Application for a Non-Material Amendment Following a Grant of Planning Permission

Proposal: Two storey rear extension to dwelling

Location: Bure Ridge, 8 Hillside Road, Horning, Norwich, Norfolk, NR12 8PG

PF/22/2426

Bure Ridge, 8 Hillside Road,
Horning, Norfolk, NR12 8PG
NNDC/22/2426B

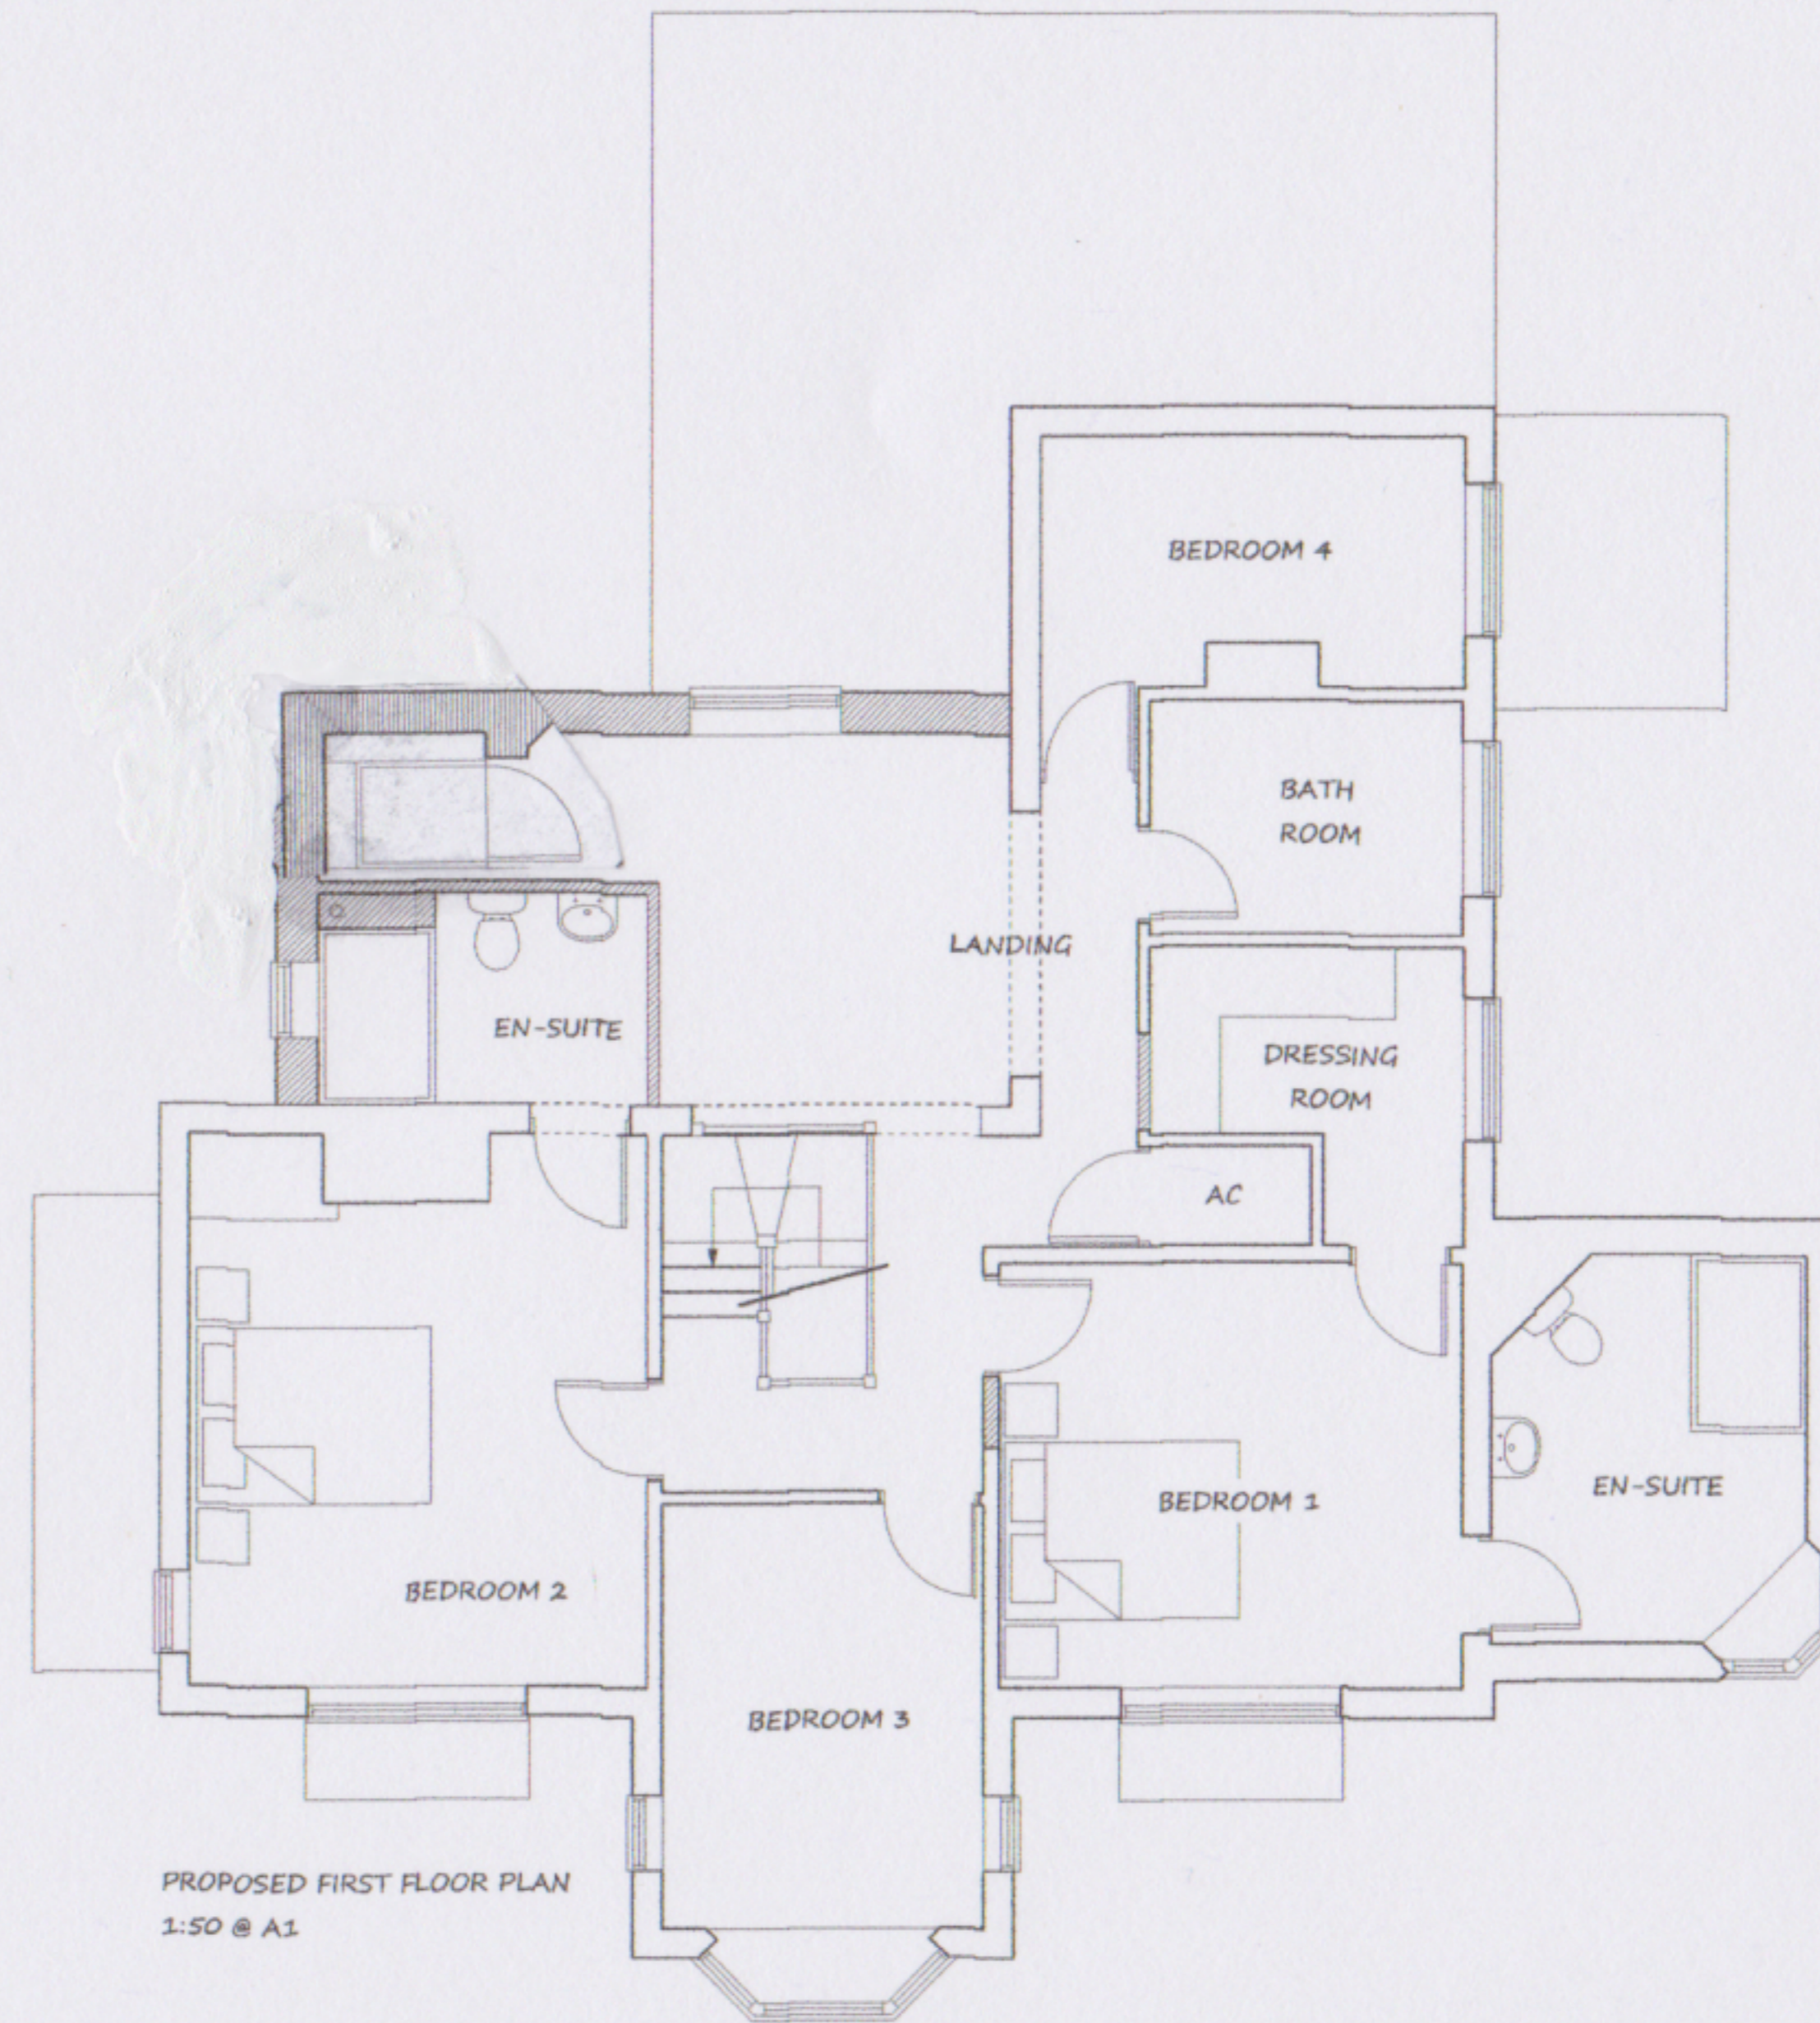
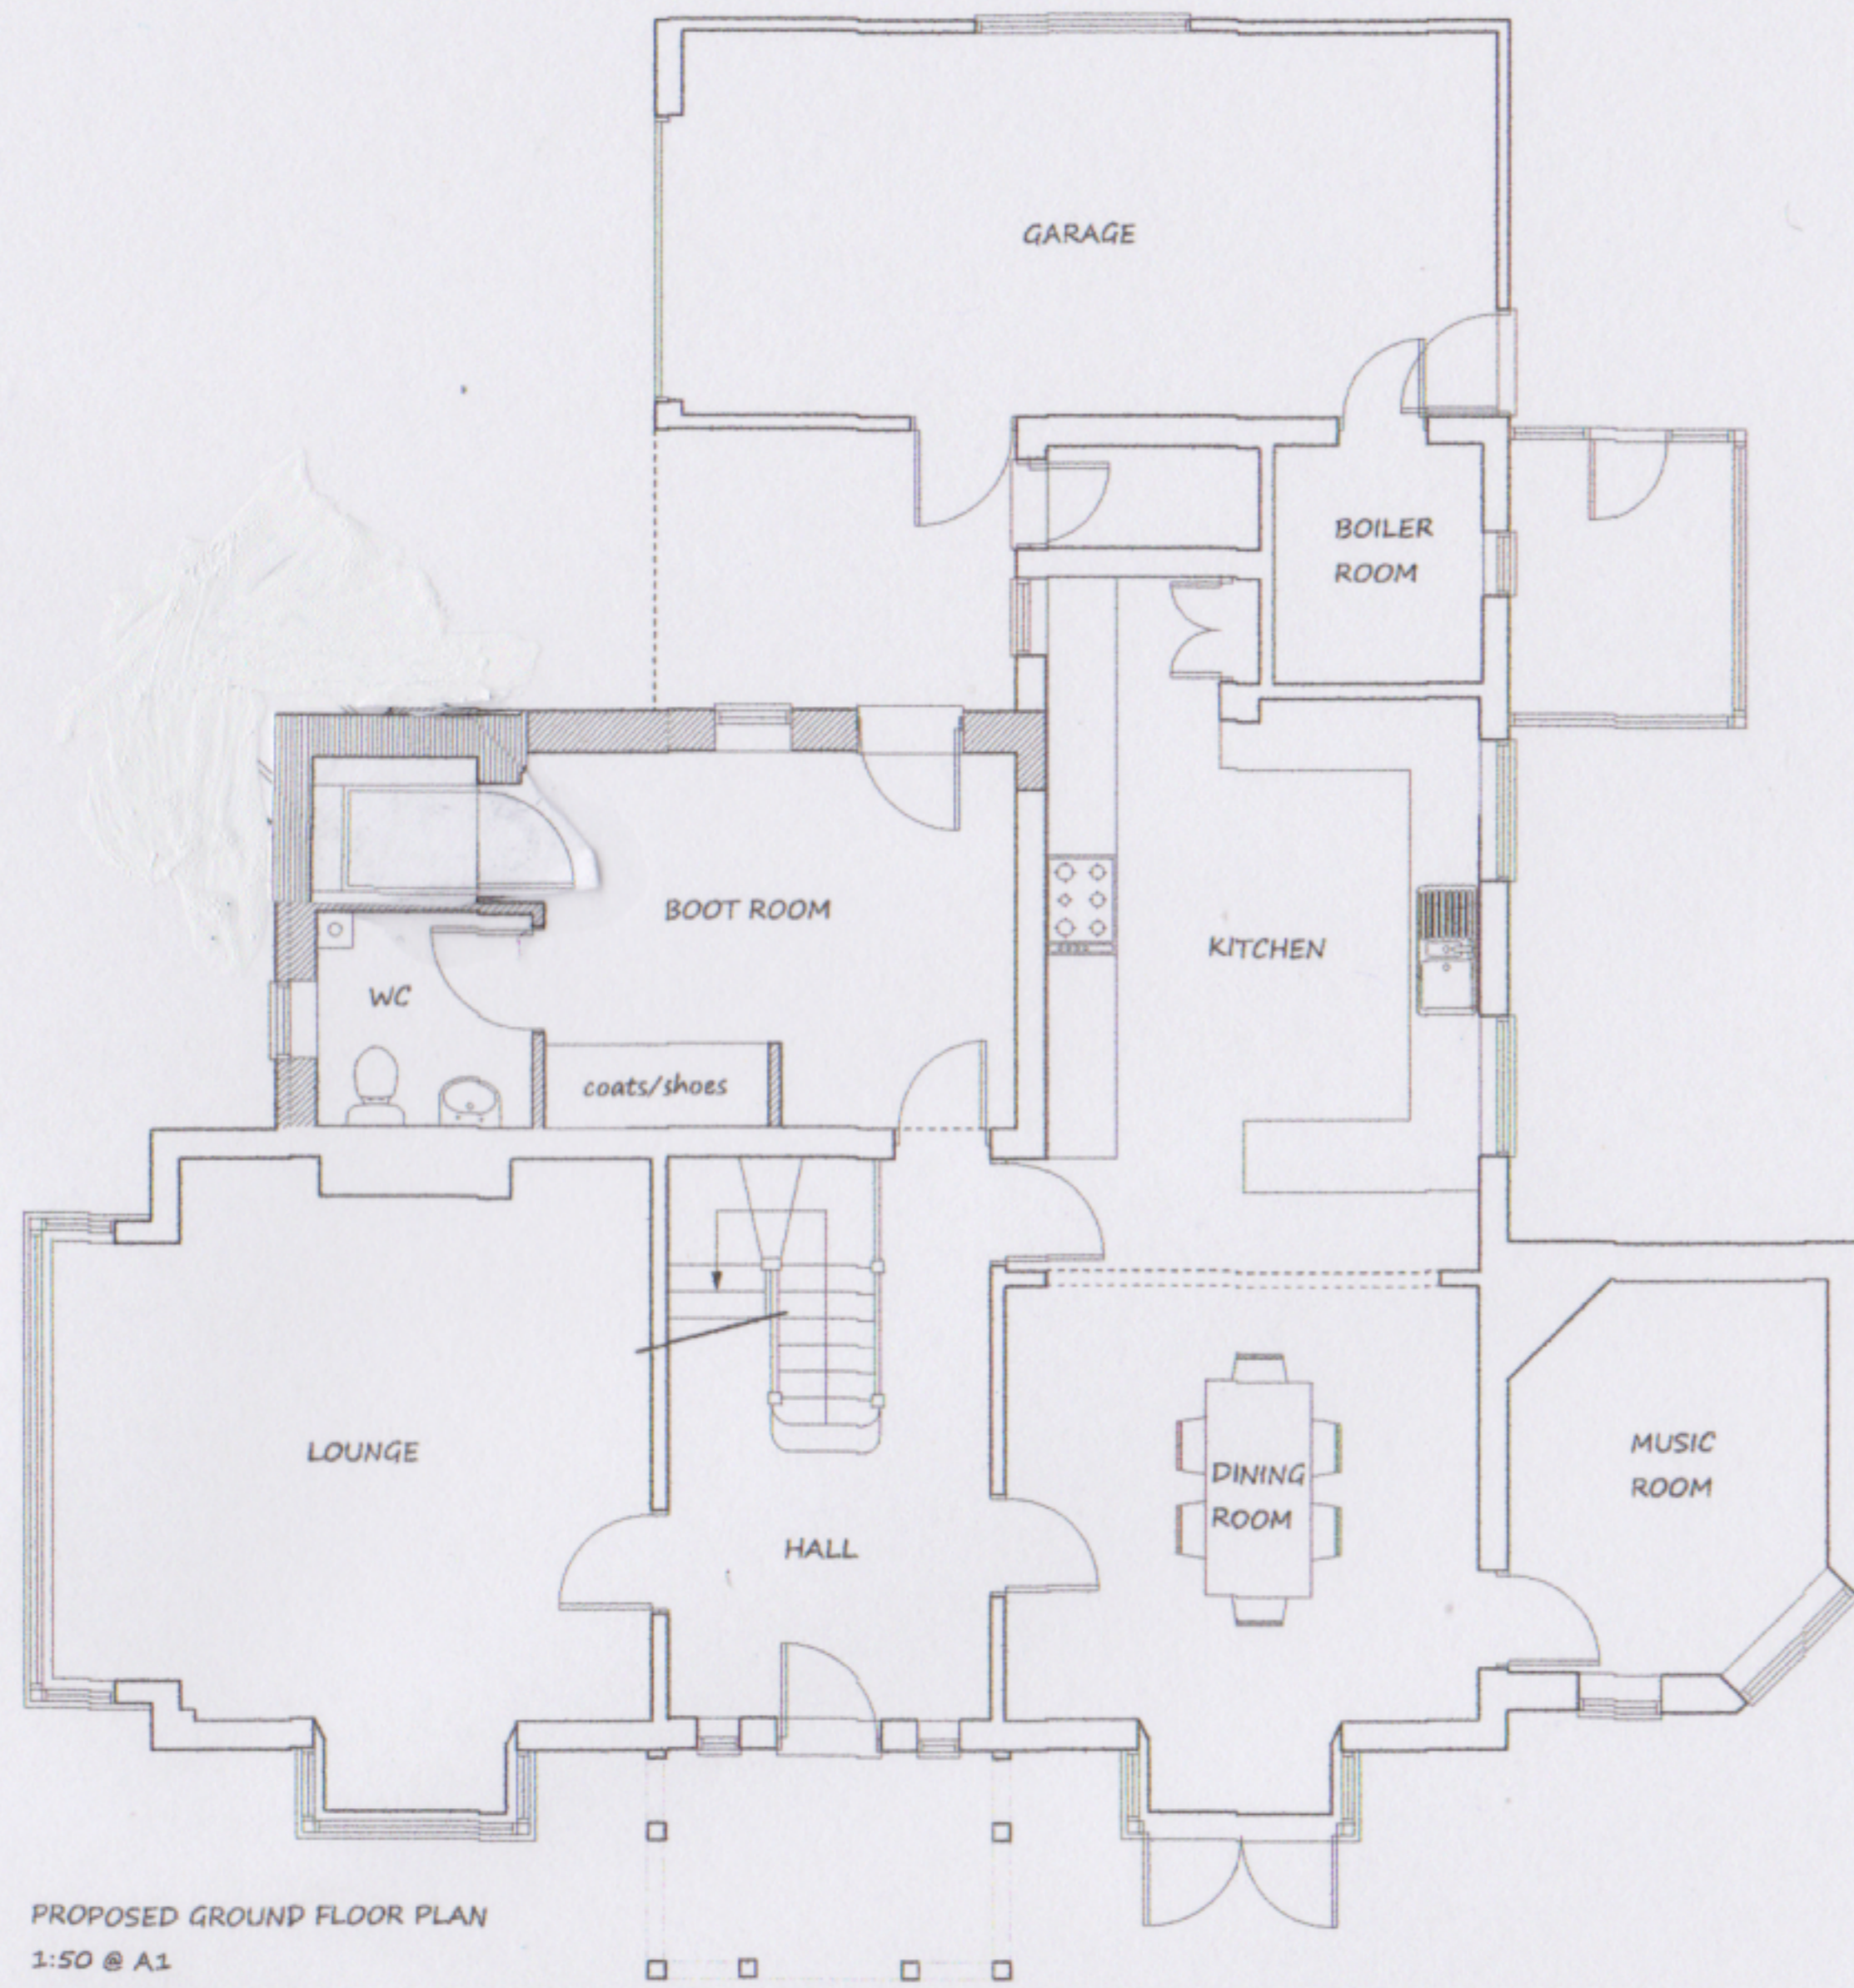
We would like to remove the 'tower' intended to house the lift.

The main reason for our initial planning application was to make our home better suited for old age as we are now both over 70. The intention was to install a lift, which we still want to do, but we think it would be more user friendly to install the lift behind the cloakroom (ground floor) and bathroom (1st floor) to avoid the angle to be negotiated to enter and exit the lift in the original plans. Should one of us require the use of a wheel chair it would make it much simpler to wheel in and out of the lift in a straight line. It would also reduce the distance required to enter and exit the lift for example with a walking frame.

NNDC/22/2426 B
